Reference: 15S1478000

15 April 2016

**RE: AUSTRALIAN TECHNOLOGY PARK, EVELEIGH
RESPONSE TO CONSULTATION**

As requested, GTA Consultants has reviewed the consultation responses to the above scheme and have commented as appropriate below. I also note that no consultation response has been received from Road & Maritime Services.

Figure 2.3: Cycle Network

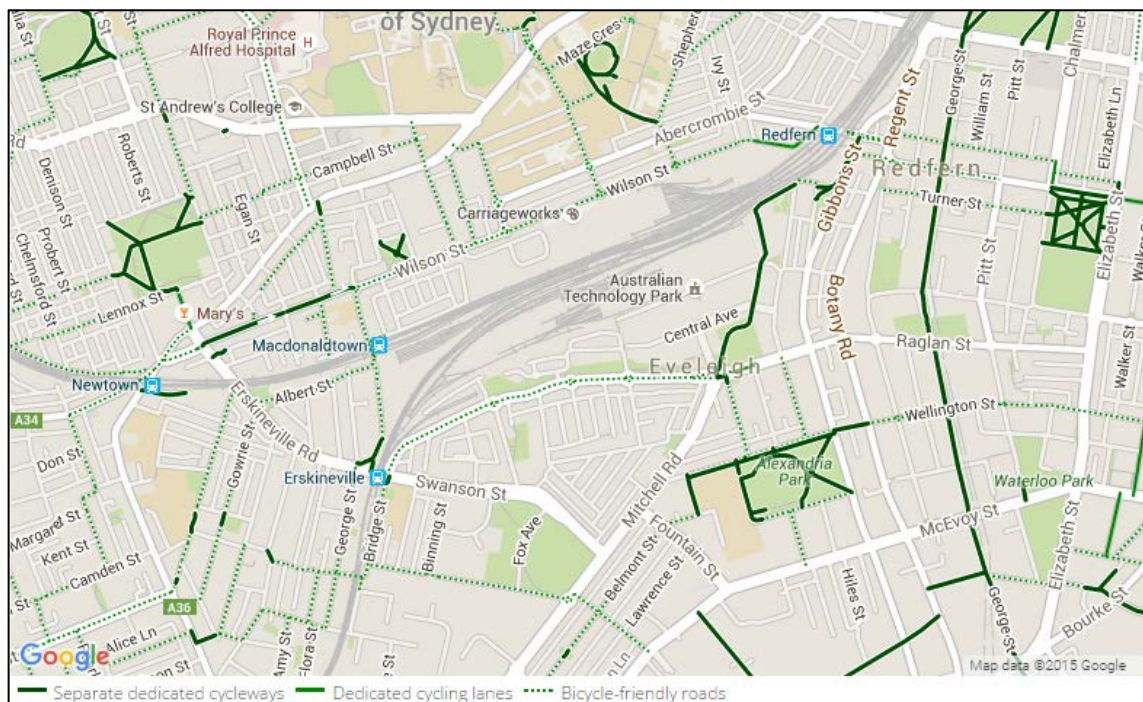
- **Figure 2.3 of Transport Impact Assessment provides peak hour turning volumes. However, no information is provided in relation to peak hour period;**

The peak hour periods recorded were 0800-0900(AM) and 1700-1800 (PM) except for Central Avenue/Garden Street where the AM peak hour was 0745 to 0845.
